WALBERTON PARISH COUNCIL
INCLUDING FONTWELL AND BINSTED
Parish Council Office, The Pavilion, The Street,
Walberton, Arundel, West Sussex, BN18 0PJ

Ref: Planning application WA/58/21/PL – Brookview Nursery, Eastergate Lane, Walberton BN18 0BA

Walberton Parish Council wishes to raise an **objection** to the above application for the following reasons.

Drawing No.	2020-6286-001	Rev.	B
-------------	---------------	------	---

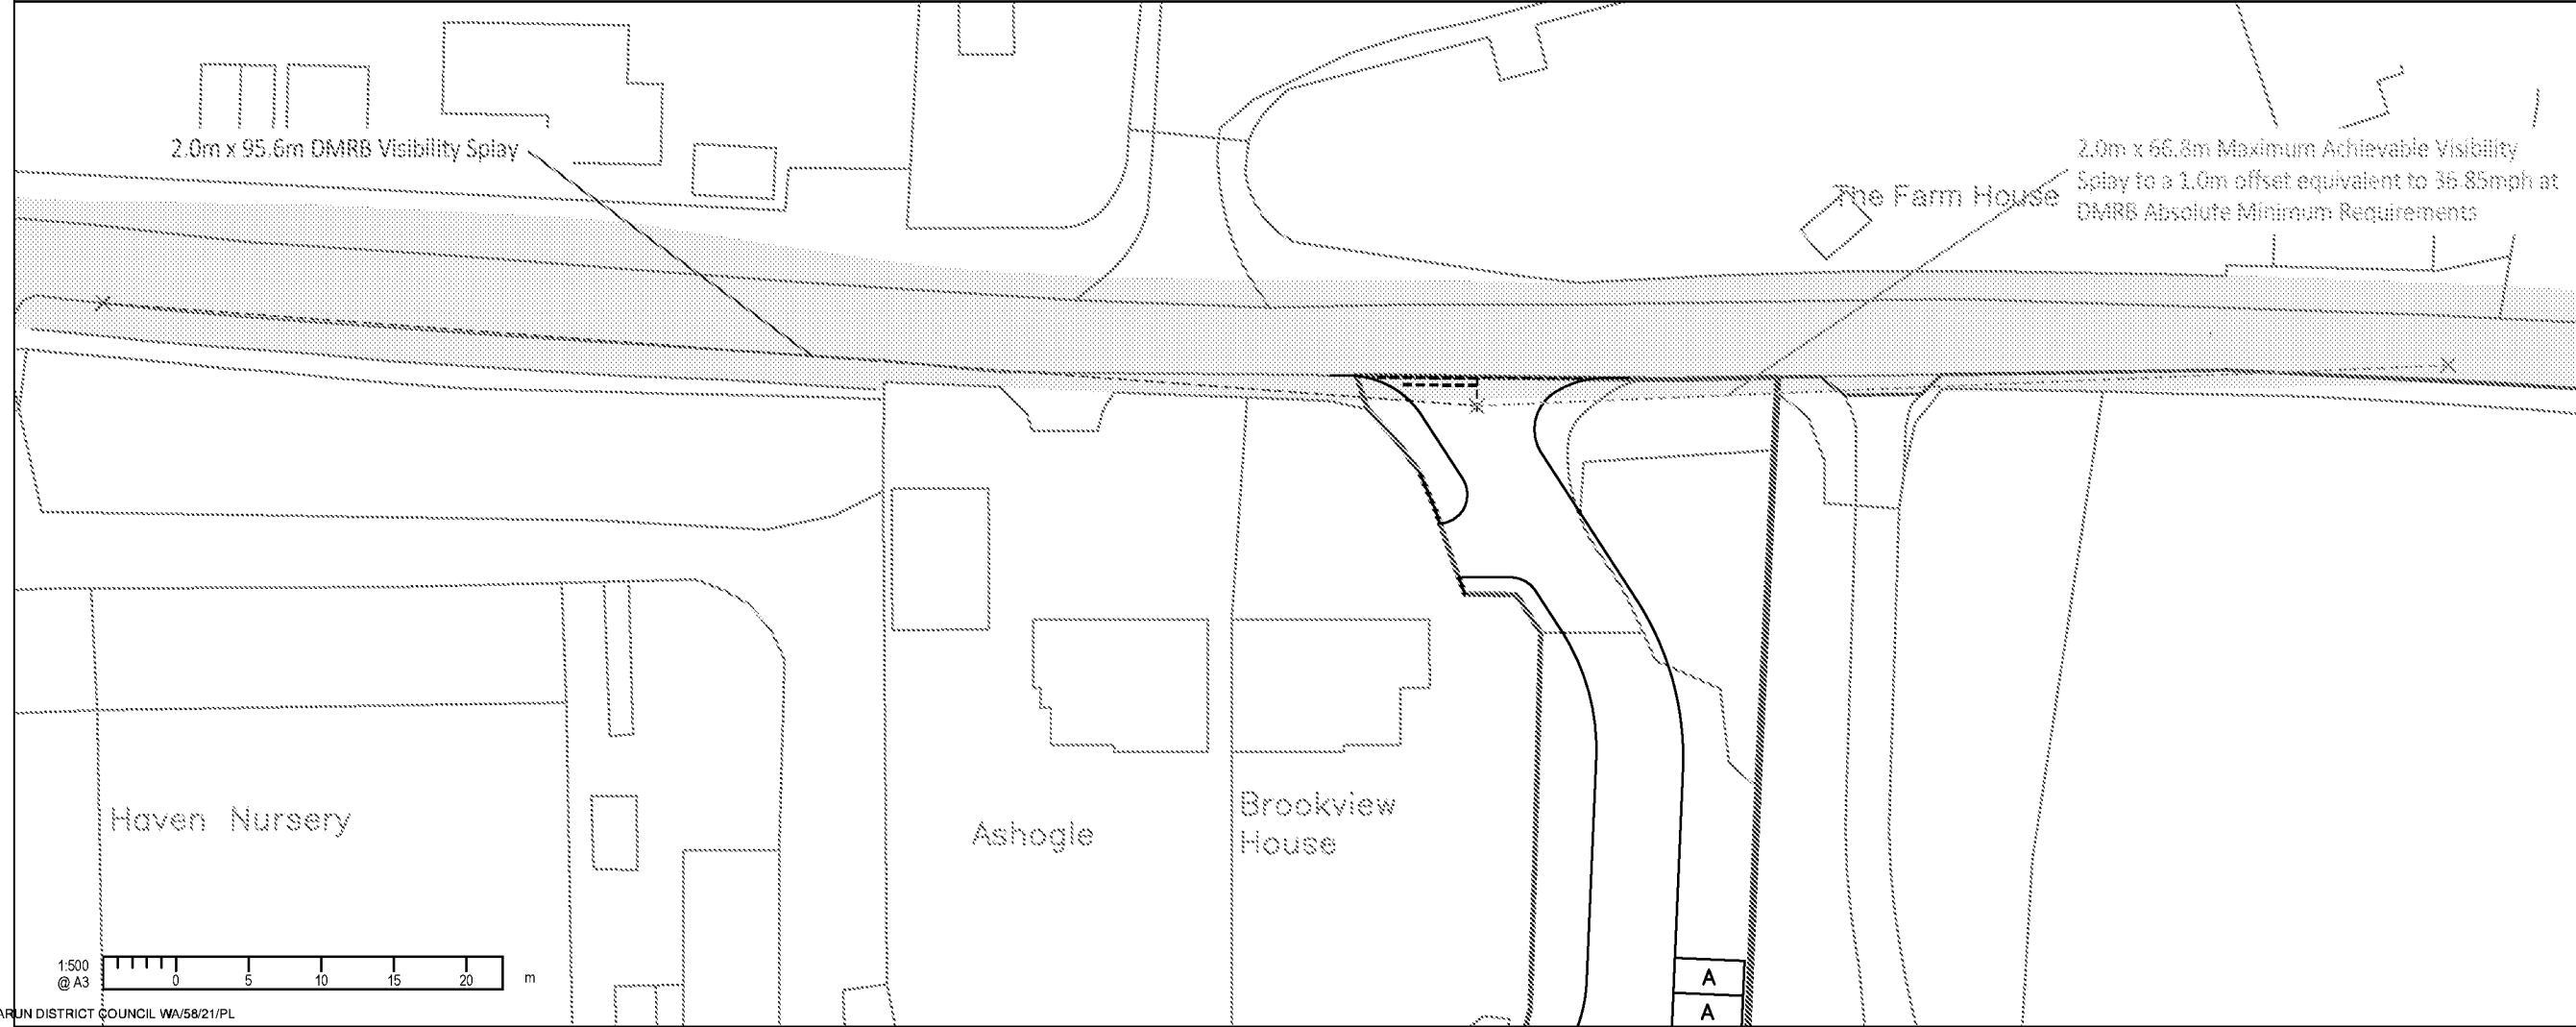
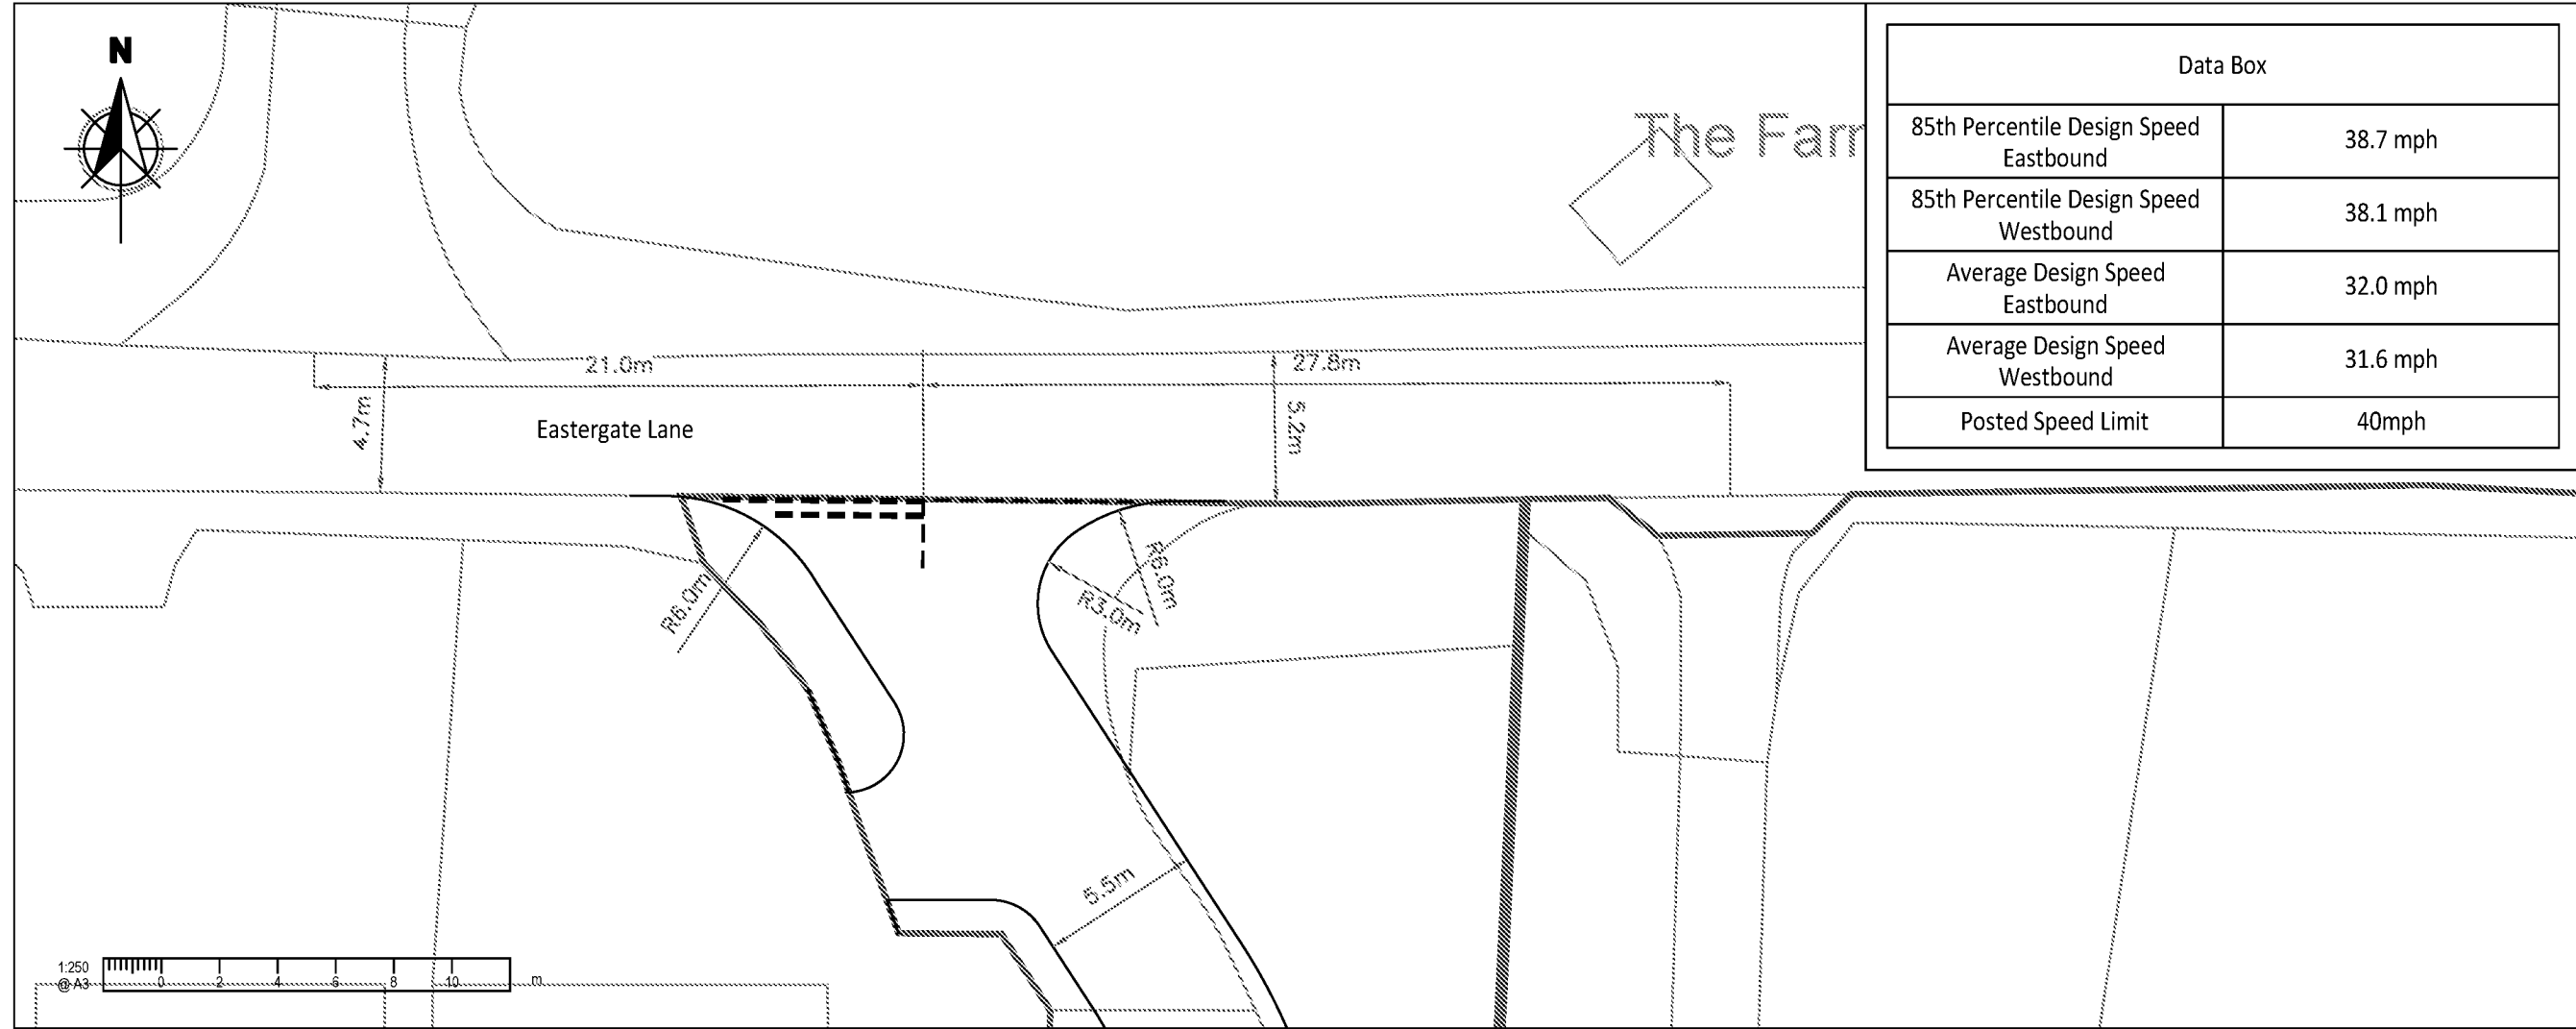
- Should the application be permitted, a condition of the carriageway in Eastergate Lane passing the development access being repaired should be applied as per the recommendation in the Road Safety Audit.
